DEVELOPMENT REVIEW BOARD
SUPPLEMENTAL SUBMITTAL

PROJECT NO. PR-2019-002184 (1001993)
Application No. SI-2019-00379

Memorandum

Re: Project Number: PR-2018-002184; Application Number: SI-2019-00379; Guardian Storage Site Plan-DRB Responses to Staff Comments

OSUNA ROAD ELEVATION ①
1/8" = 1'-0"

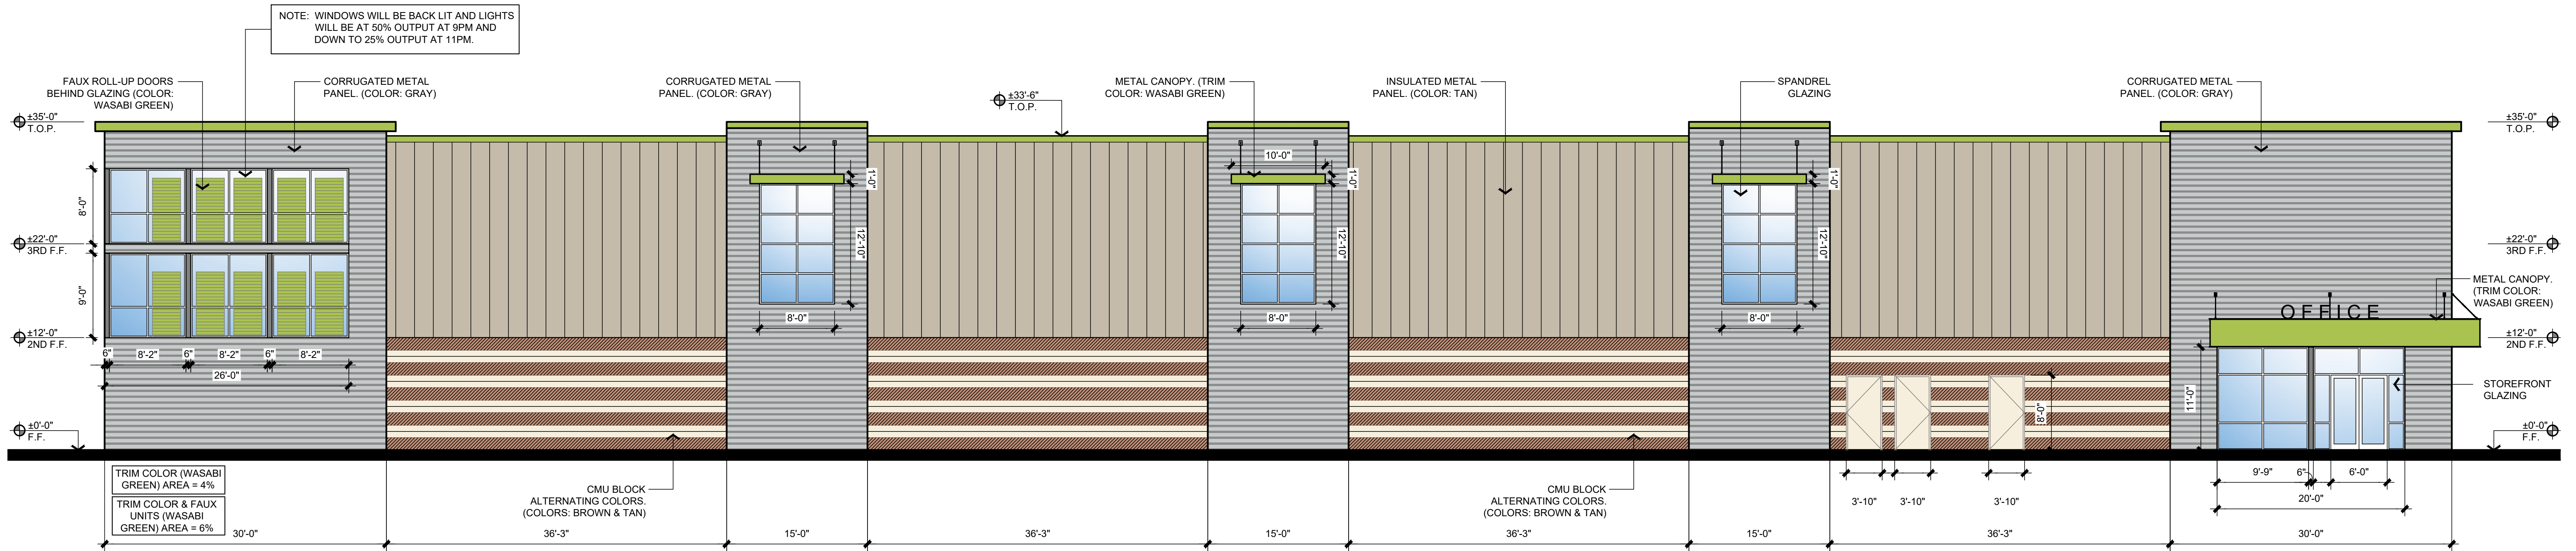
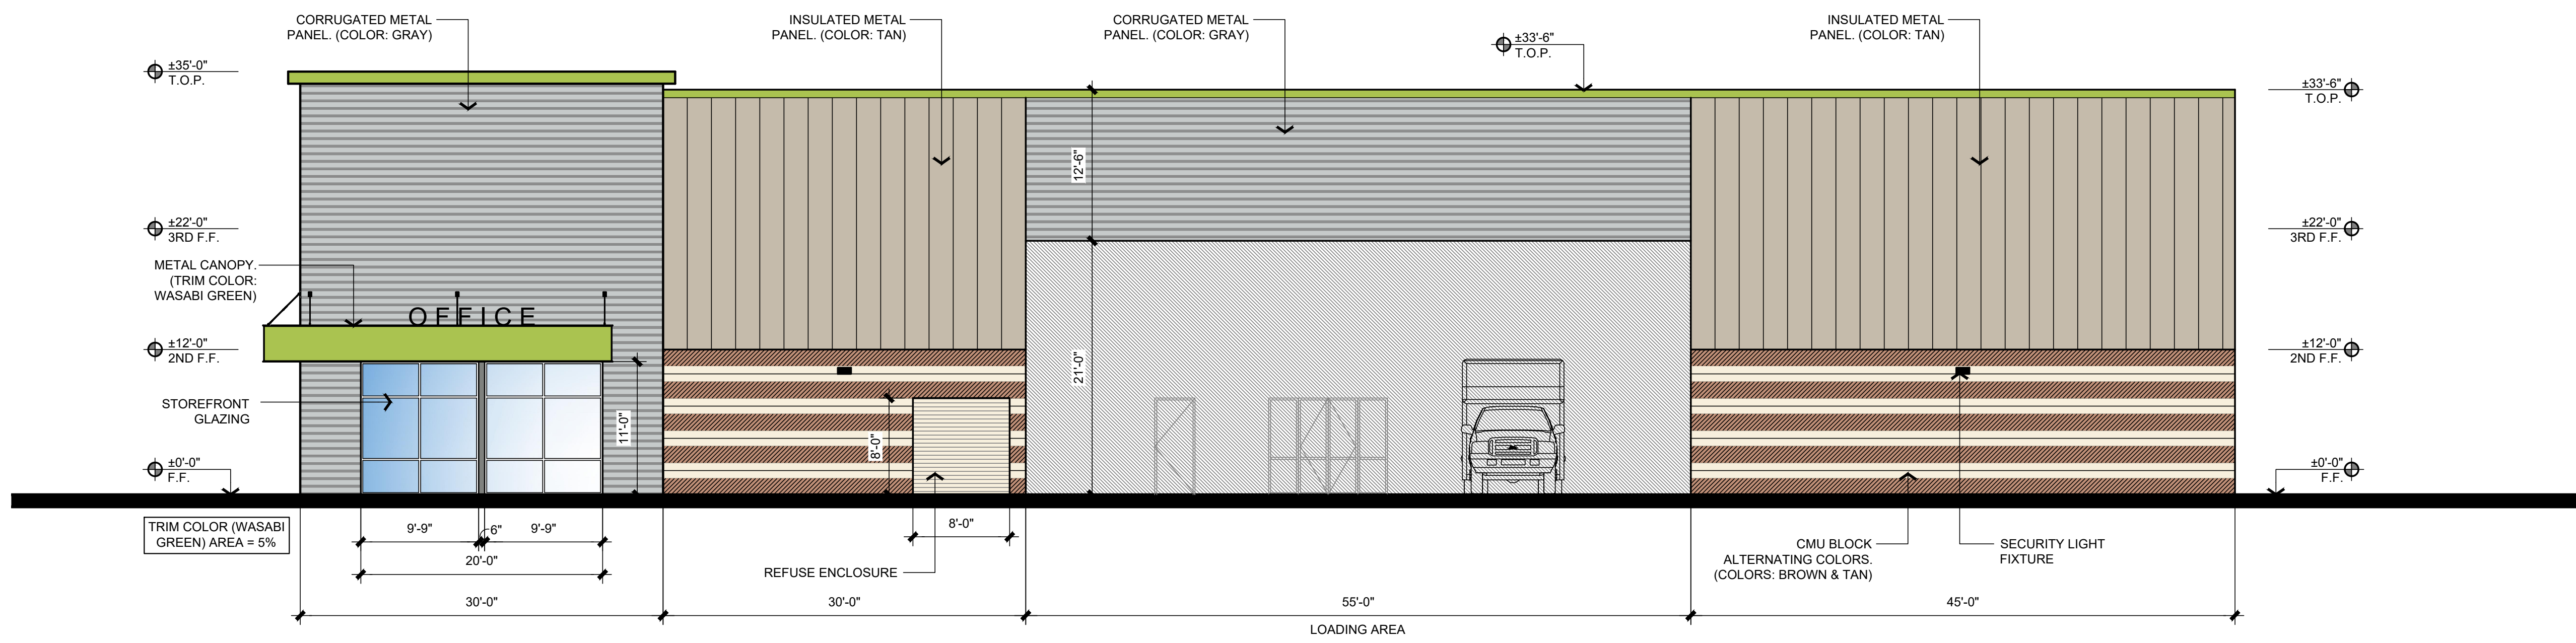
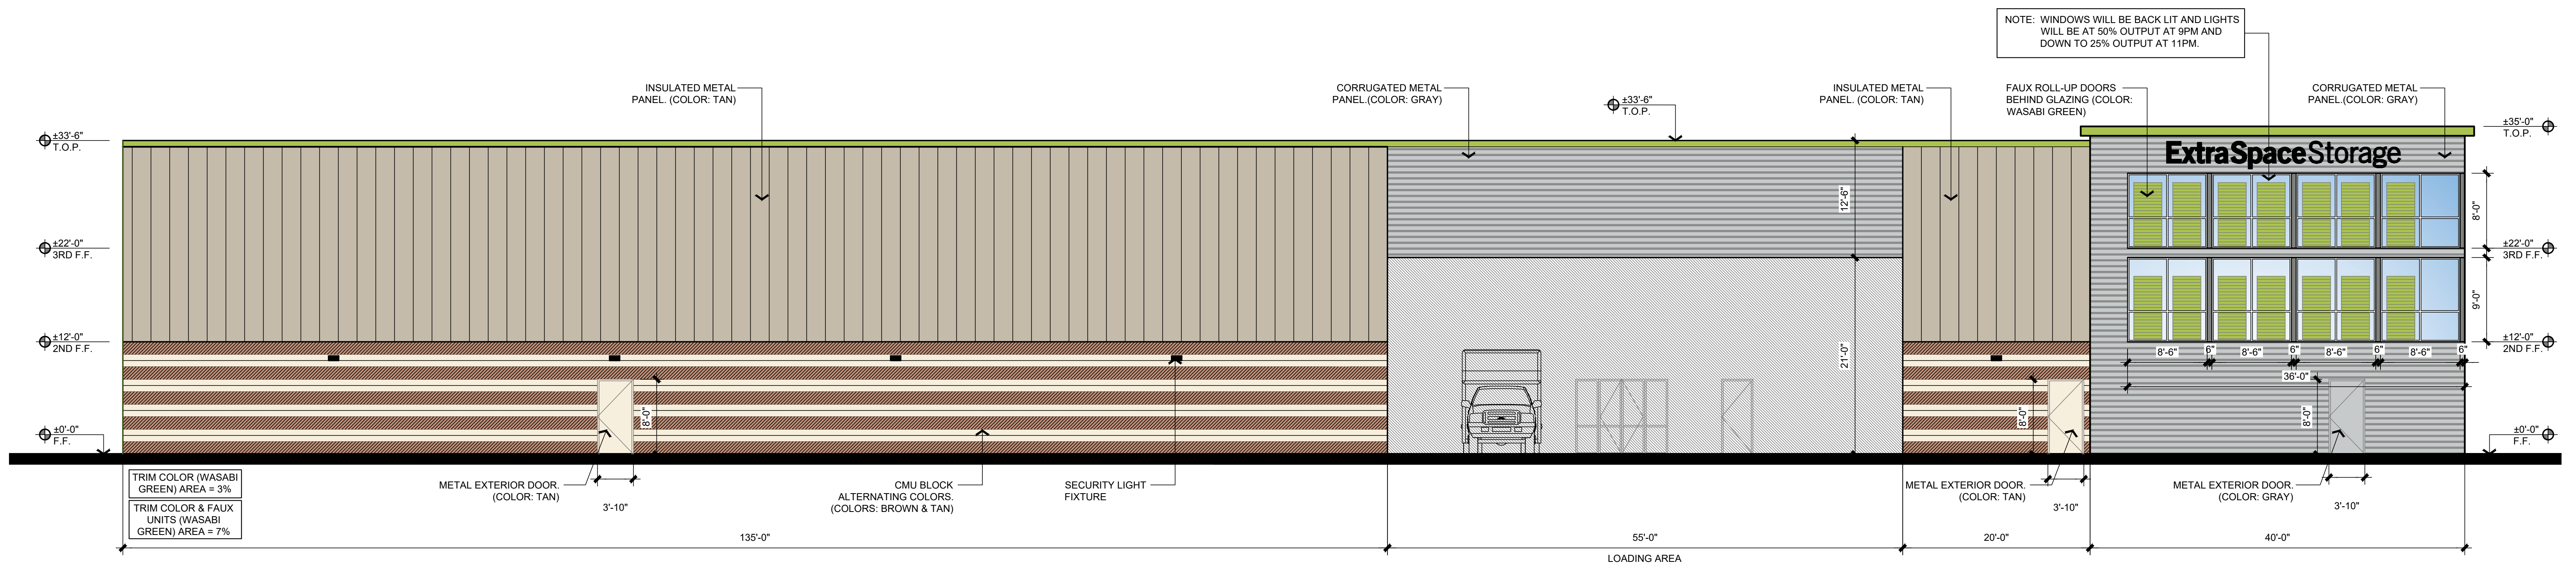
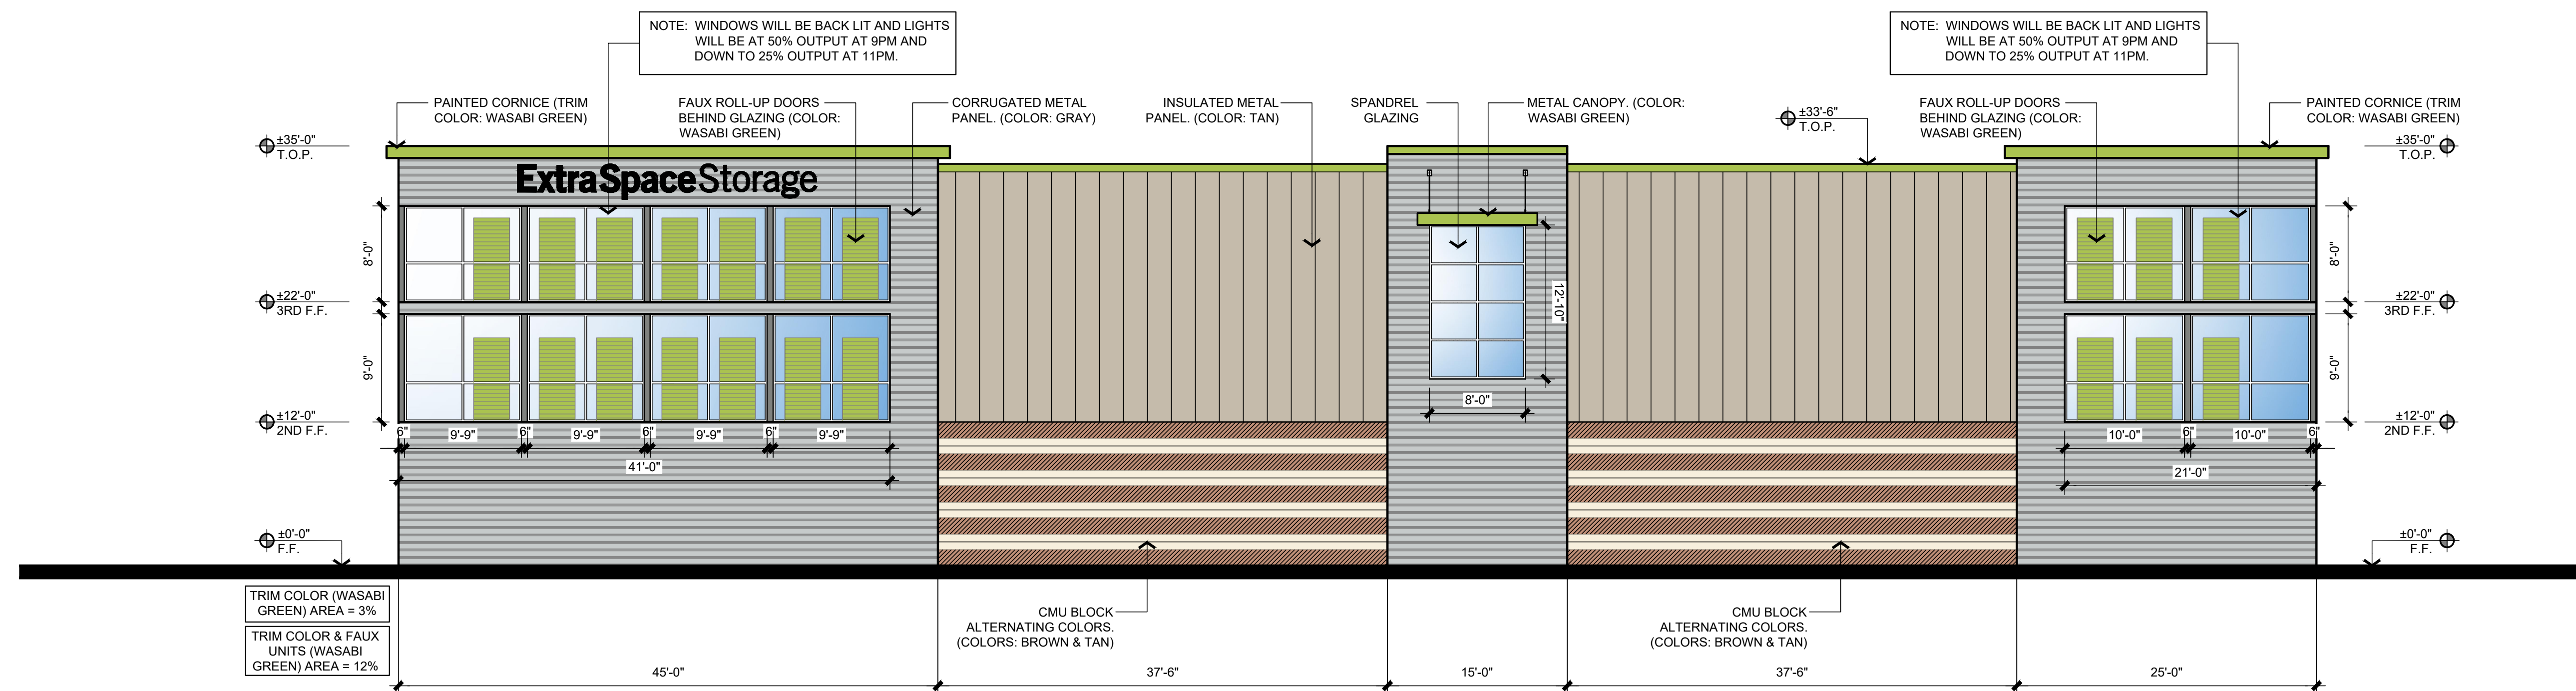
5. *Make sure that façade design in 14-16- 5-11 is being met.*

13. *Do building colors meet 5-2(H)(1)(a) for reflectivity. Please provide information for the colors used in the building.*

14. *Please clarify the shade of green, Pursuant to 5-2(H)(1)(b) colors must blend into the surrounding environment, yellow ochres, browns, dull reds and grey greens- please confirm that is a grey green.*

Applicant Response: The following responses pertain to *IDO Section 5-11(E)(2)(a):*

1. The first floor is 12' which provides a sense of human scale with the subsequent floors being 10', respectively. There are building material changes from the ground floor to the upper floors, providing a clear architectural distinction.
2. The building façades facing the public streets of Juan Tabo Boulevard and Osuna Road incorporate three of required façade features, exceeding the requirement of two. They include:
 - b. Material changes with windows at the upper floors less than 40 linear feet apart.
 - c. Primary pedestrian entrance on Osuna Road façade.
 - d. Window elements contain canopies and shade awnings with accent color.

These features comprise 42% (exceeding the required 30%) of the Osuna Road façade and 53% of the Juan Tabo Boulevard façade. On both streets, they occur every 36' 3".

3. Both frontages are greater than 100 feet and exceed design requirements by incorporating two of the required features:
 - b. Color and material changes throughout the façade every 36' 3" linear feet and extends at least 20 percent of the façade.
 - e. Changes in parapet height occurring every 36' 3".
6. *Clarify how fencing requirements in 14-16-4-3(D)(28) are met, the fencing appears to stop before the property ends and does not appear to be opaque.*

Applicant Response: Yes, these colors are below the 50% threshold per *IDO Section 5-2(H)(1)(a)*. A color and reflectivity table has been added to the elevation sheets for all painted exterior surfaces.

Applicant response: The shade of green illustrated on the elevations is Wasabi Green, a trim color. *Per 5-2(H)(1)(b)1, trim materials constituting less than 20% of the façade may be any color and the design is in compliance.* Please see below for percentage of trim on each elevation:

Osuna Rd. Elevation
Trim Color w/Faux Units: 6%

West Elevation
Trim Color: 5%

South Elevation
Trim Color w/Faux Units: 7%

East Elevation
Trim Color w/Faux Units: 12%

Total façade percentage with faux units = 7.5%
